WEST SUSSEX COUNTY COUNCIL CONSULTATION

TO:	Arun District Council FAO: Anita Gardner
FROM:	WSCC - Highways Authority
DATE:	17 June 2019
LOCATION:	7 Thorncroft Road, Littlehampton, BN17 6DD
SUBJECT:	LU/87/19/PL Demolition of existing shed & erection of 1 No. 1 storey cabin with habitable roof space.
DATE OF SITE VISIT:	N/A
RECOMMENDATION:	Advice
S106 CONTRIBUTION TOTAL:	£N/A

BLOCK PLAN

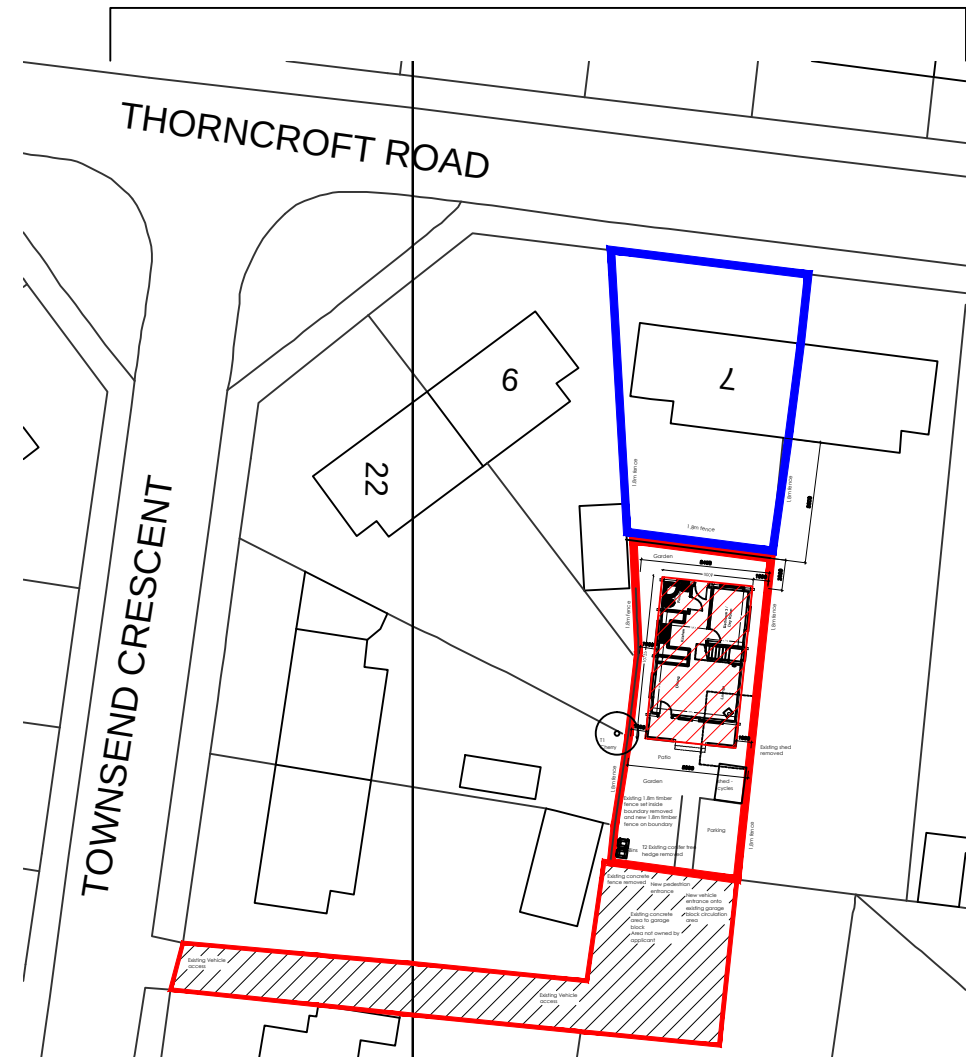
1 car parking space is proposed for the ancillary cabin. The parking space meets minimum dimensions for single car bays as set out in Manual for Streets. This is anticipated to be sufficient for the needs of the ancillary building. A shed is also proposed to store cycles. There is sufficient room for turning, allowing vehicles to exit onto Townsend Crescent in a forward gear.

No part of the development shall be first occupied until the car parking has been constructed in accordance with the approved site plan. These spaces shall thereafter be retained at all times for their designated purpose.
